ACCESS REPORT

PROJECT: PLC – Secondary Innovation Precinct (SIP) and Campus Commons
PROJECT NO: GDL240387.1
PREPARED FOR: Pymble Ladies College
REVISION: C
DATE: 27/05/2025

PROJECT NORTH
DRAWING
GA PLAN - BASEMENT 01
DRAWING NUMBER
AR-SIP-DA-A02-10B1
ISSUE
4

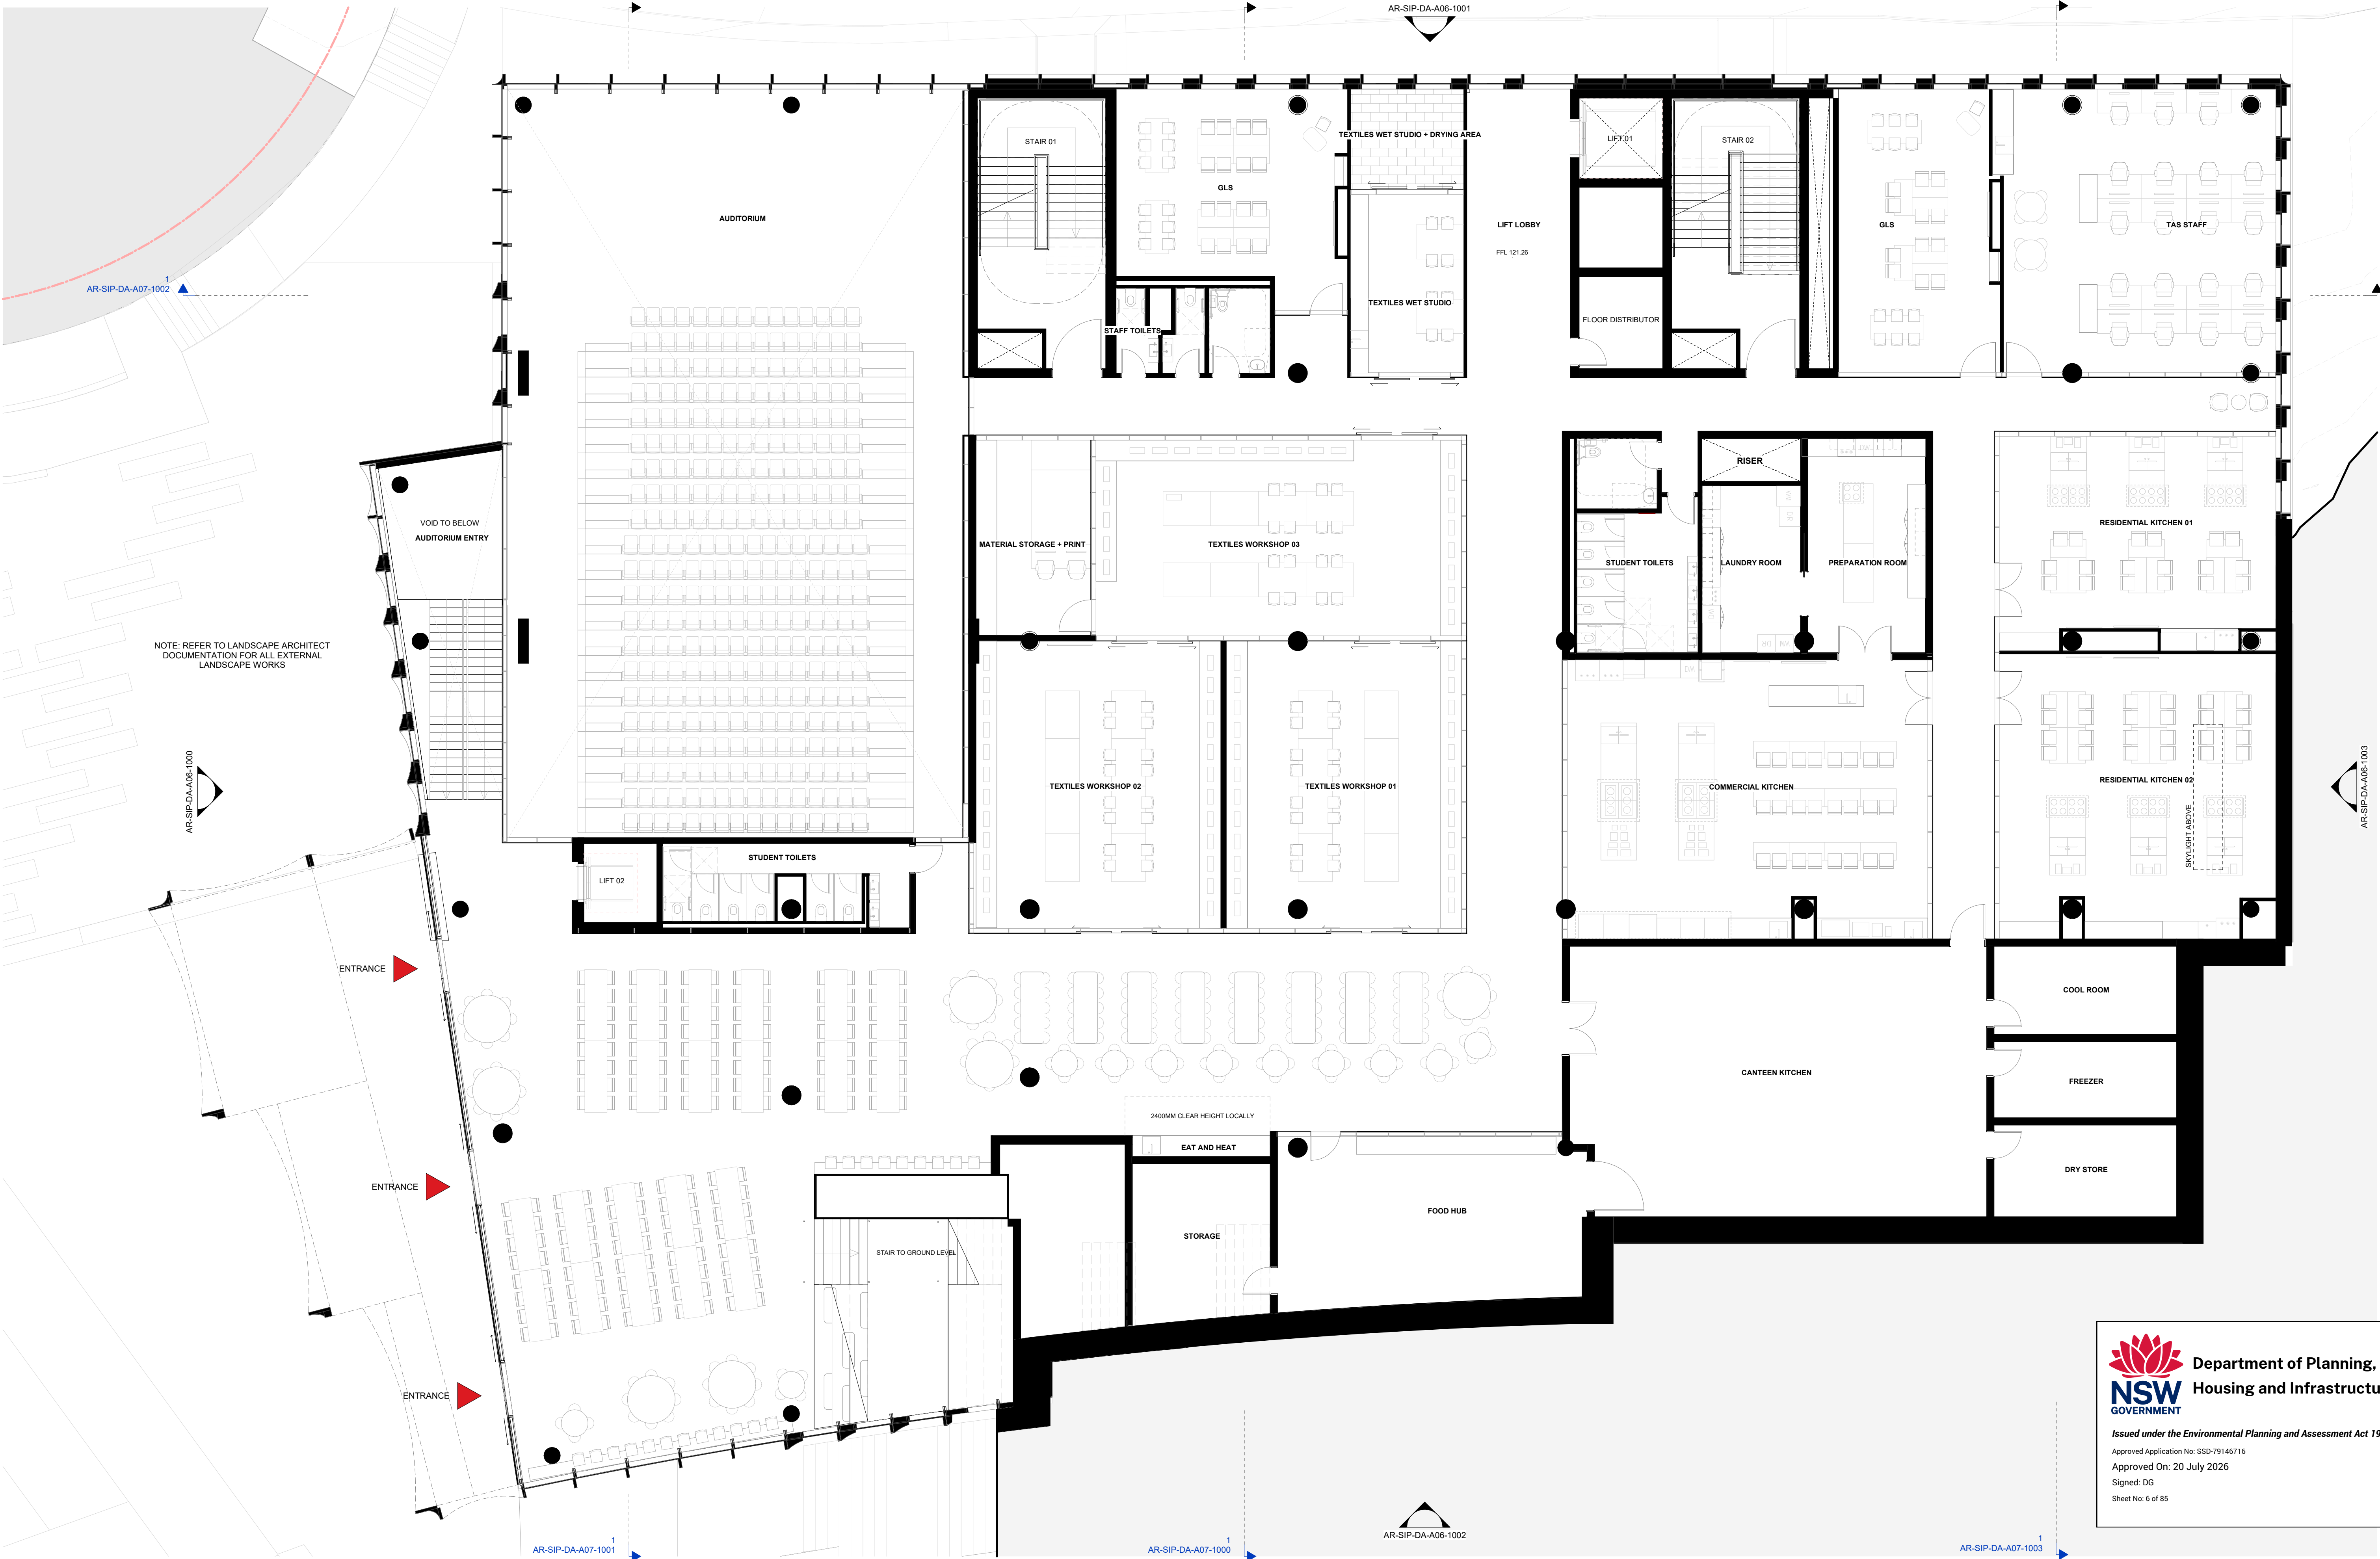
14.	Basement 01 Staff Male Ambulant and Female Ambulant	The entry door location affects the 900 x 900 min. clear circulation on the internal side of the ambulant toilet cubicle due to proximity to and vanity obstruction.	Design review required of door position to ensure 900 x 900 circulation space clear provided directly in front of open-door swing (currently is off-set) - Refer AS1428.1:2009 Fig 34	F4D6	FP2.1

ELEVATION - EXISTING FERGUSON BUILDING

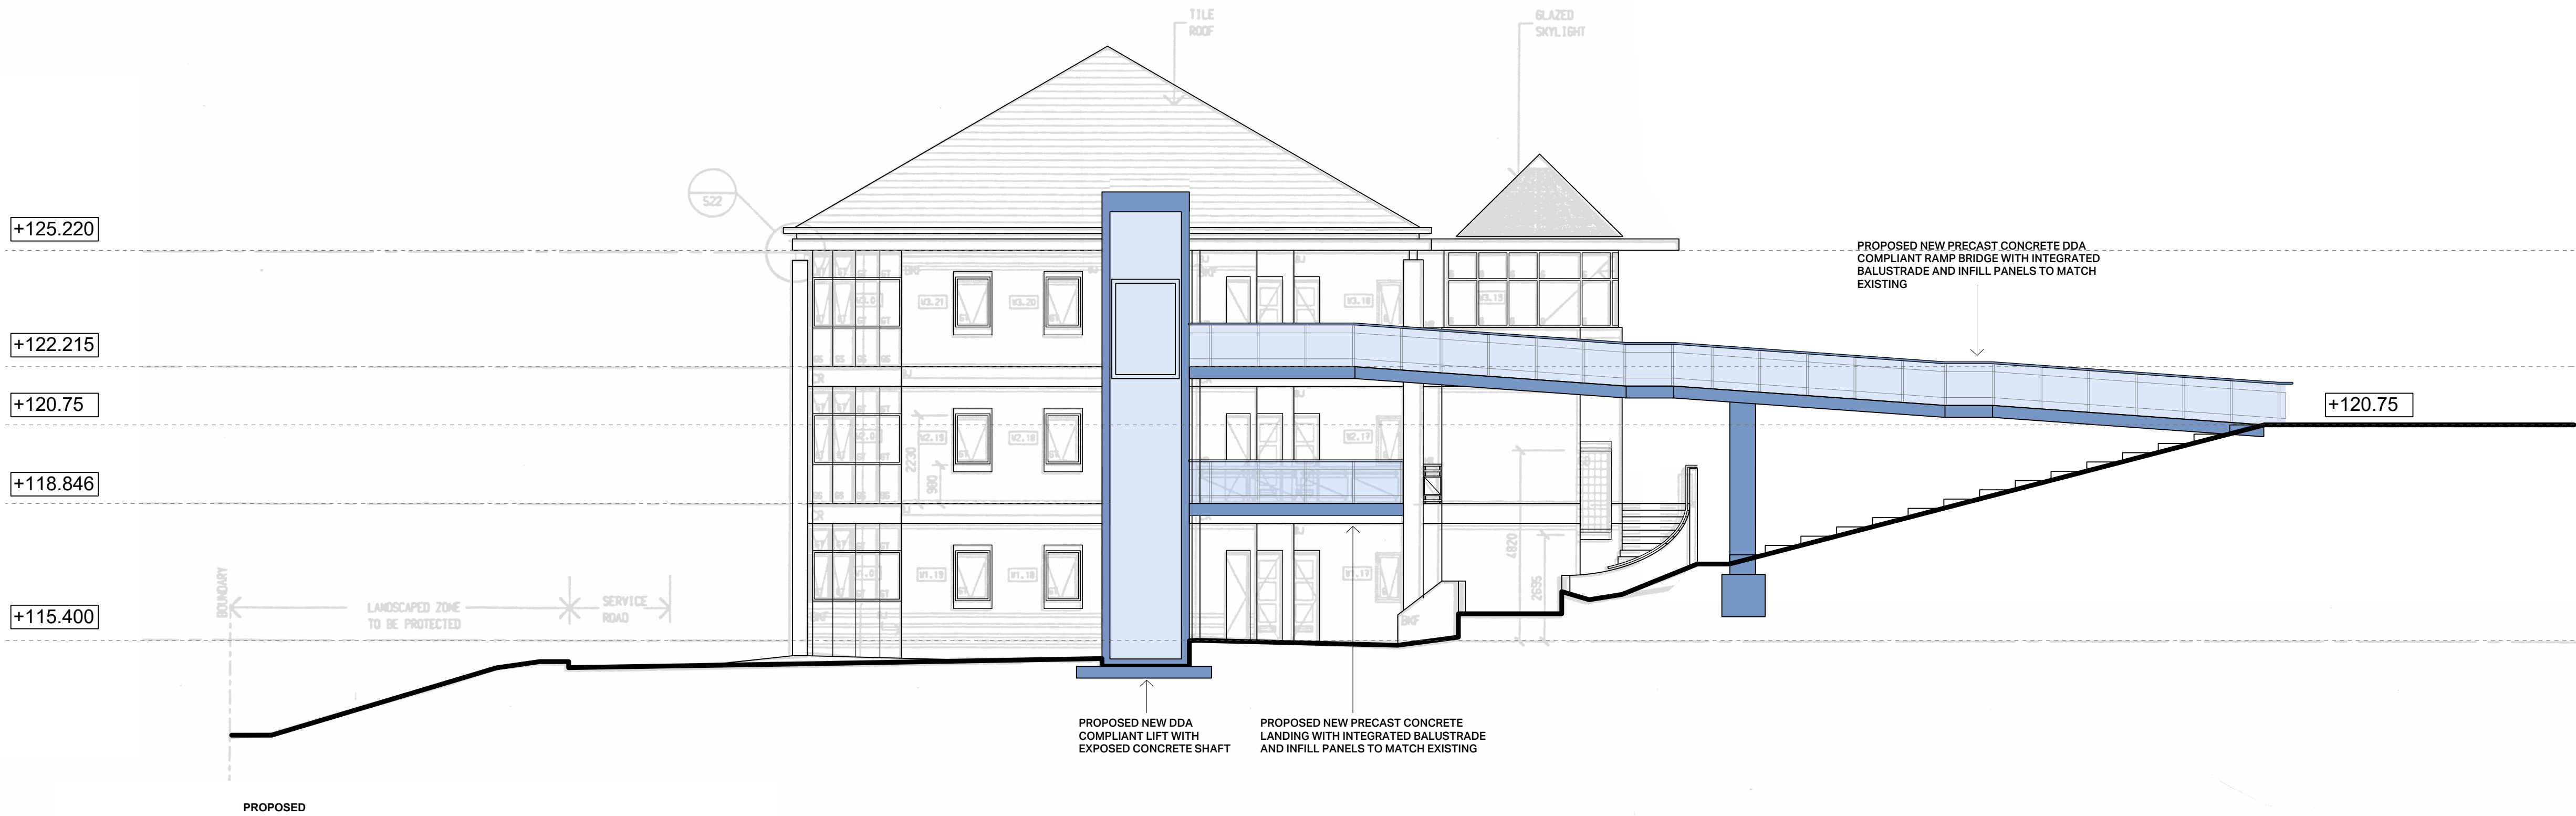
16.	Existing Ferguson building – upper-level access (interface area)	The demolition of Vicars House building (with existing lift, assumed non-compliant) removes the step free path of travel to and within the upper building levels of Ferguson building, as it is currently connected and shares the use of the lift (that will be removed).	To improve equitable access and assist mitigate DDA risk in the short term, the school is to provide an operational management plan for use of alternate equivalent facilities in accessible area for a person with disability eg. Scheduled use and functional operation of classrooms at accessible building level/s in lieu of non-accessible levels. Note: This may require justification as a potential Performance Solution, subject to Project Certifier advice – TBC. <i>Consideration of a longer-term solution ie. by providing a new compliant ramp (and lift) access as part of phased upgrade access strategy for the Ferguson building as part of a separate future project is recommended – DDA/Advisory</i>	D4D4 DDA	D1P1 DDA

17.	Existing Ferguson building – ground level access (interface area)	The demolition of existing (non-compliant) external ramps and stairs to the Ferguson building removes the step free path of travel to ground level from south/eastern approach, resulting in stair access only between ground level areas required to be accessible.	An Access Performance Solution would be required to justify the single handrail provision (required for the stair platform lift) with the school operational management plan (existing) to be updated <i>Consideration of a longer-term solution ie. by providing a new</i>	D4D4 DDA	D1P1 D1P2

Amphitheatre Plan

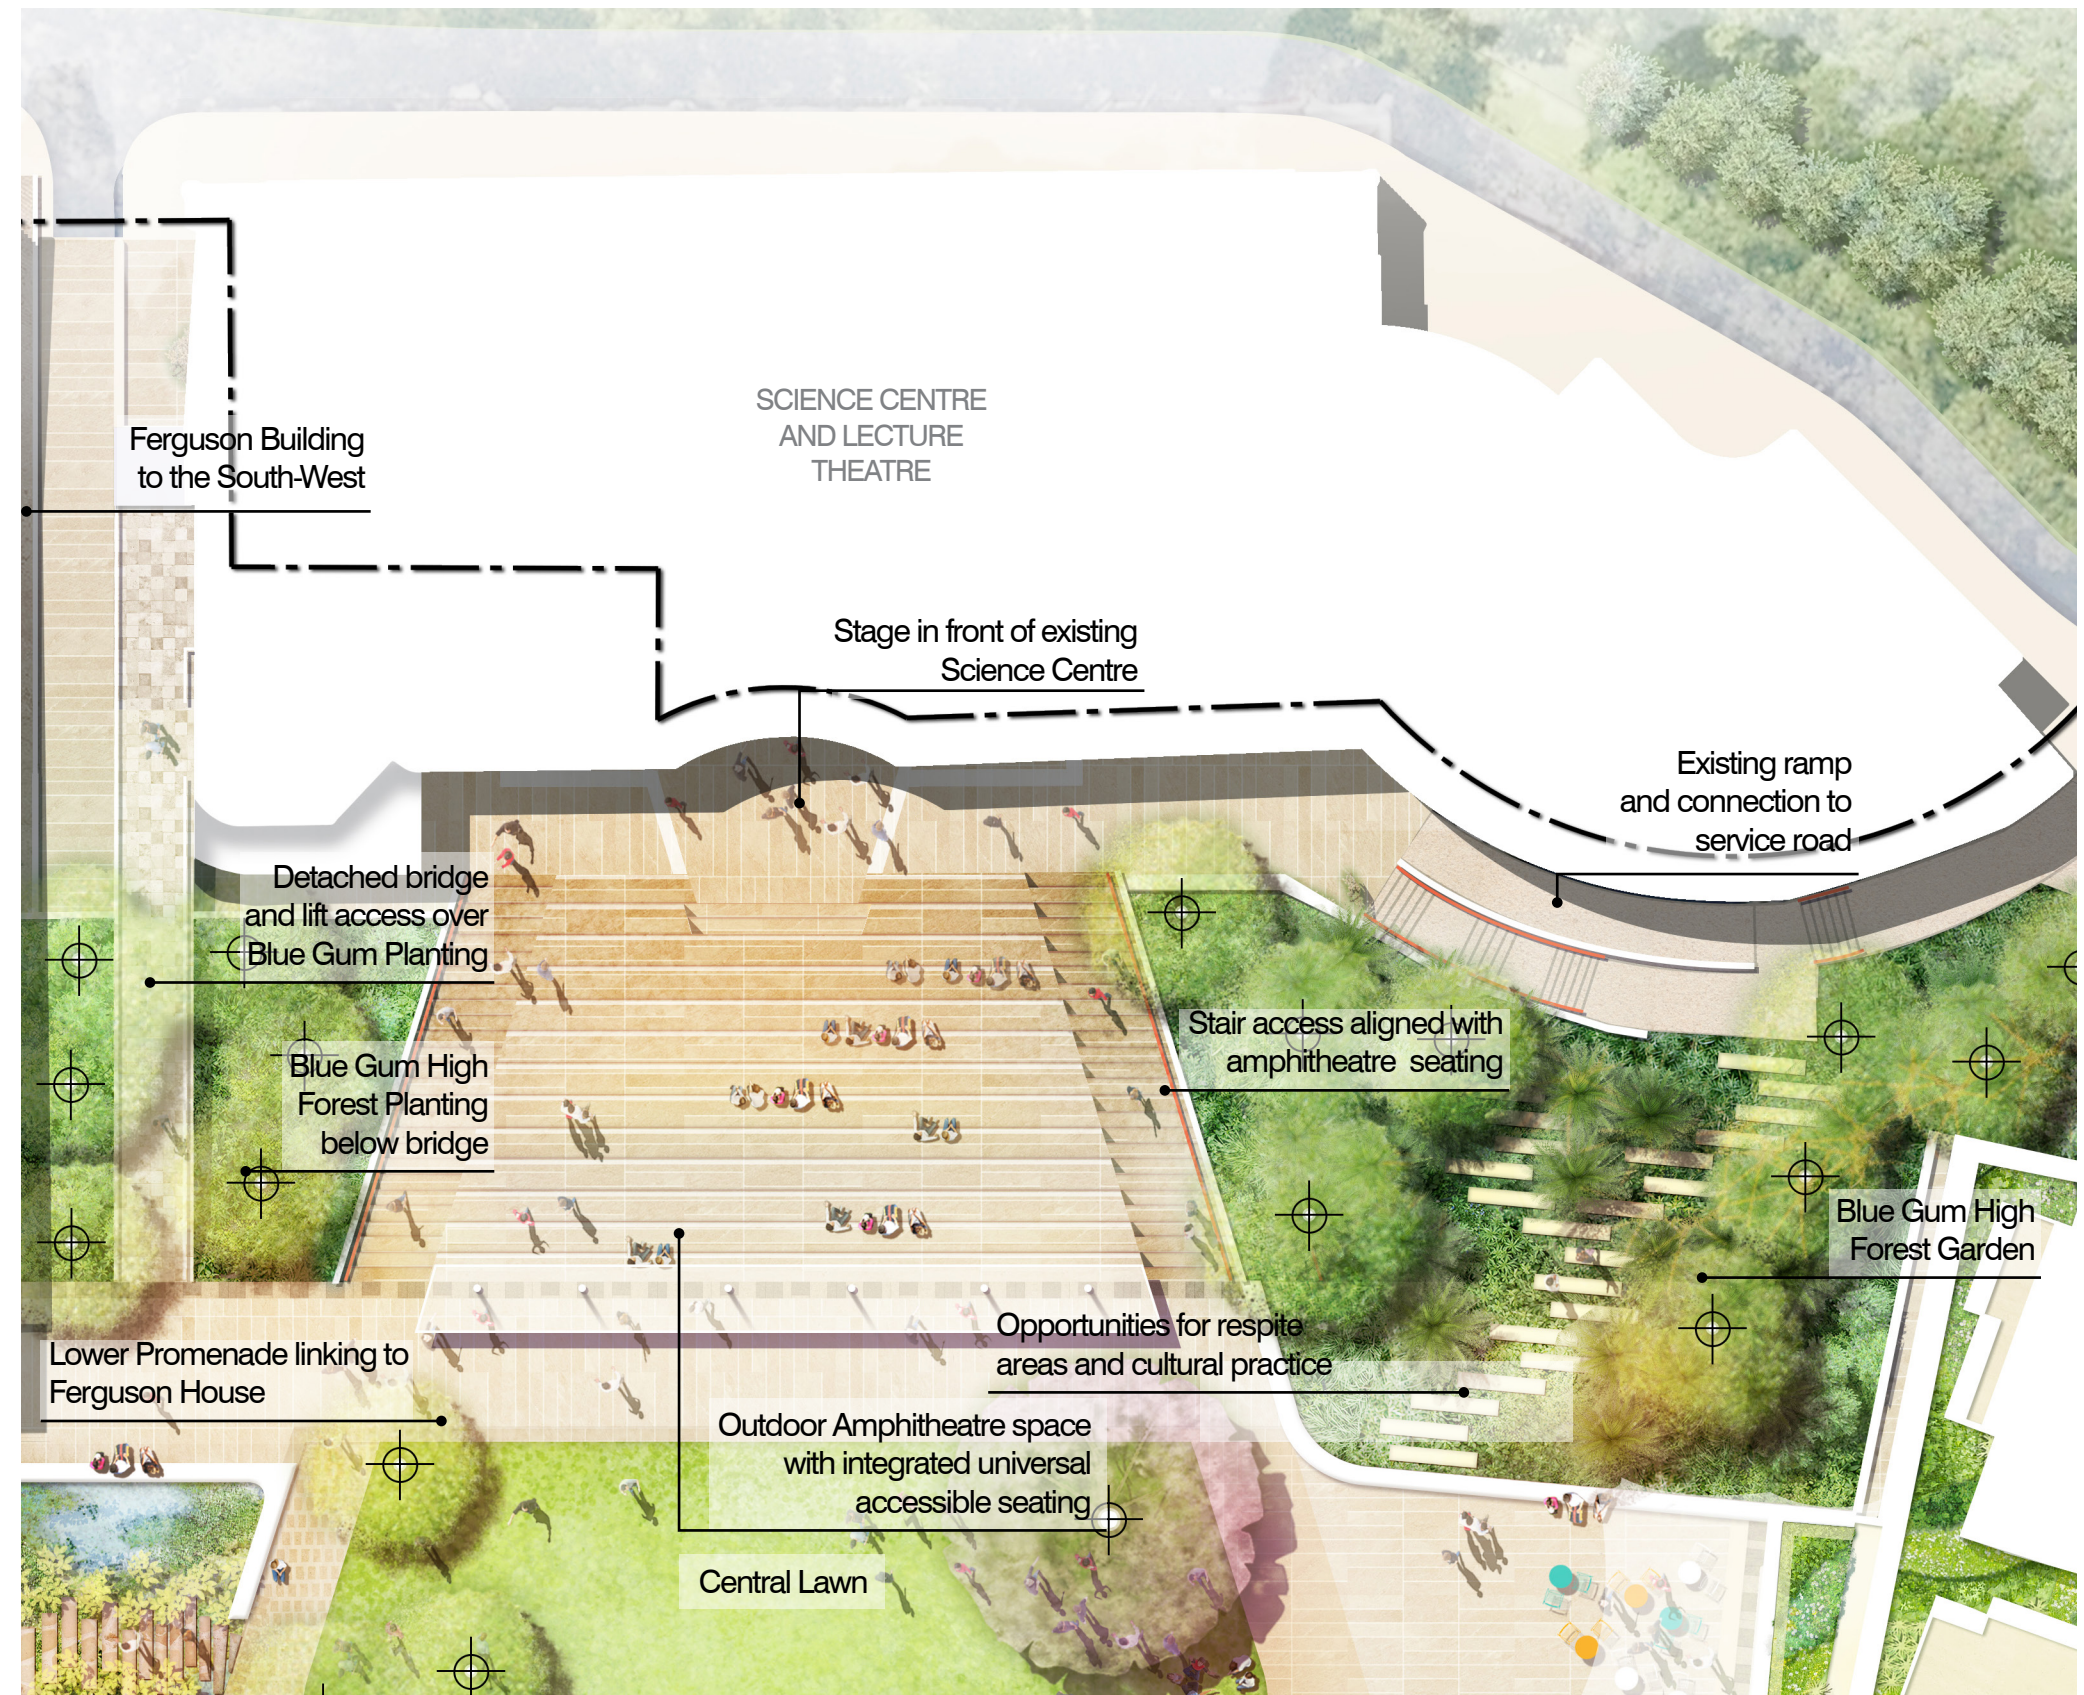
3.	Landscape Amphitheatre Stairways	Continuous handrails not provided on internal sides of each of the two (2) stairways for ease of access to the bleacher/tiered seating.	An Access Performance Solution will be justified by the continuous external handrails on each of the stairways that will otherwise comply with AS1428.1:2009 and step nosing with increased luminance contrast for improved detectability (45% min.	BCA D4D2, D4D4	D1P1, D1P2
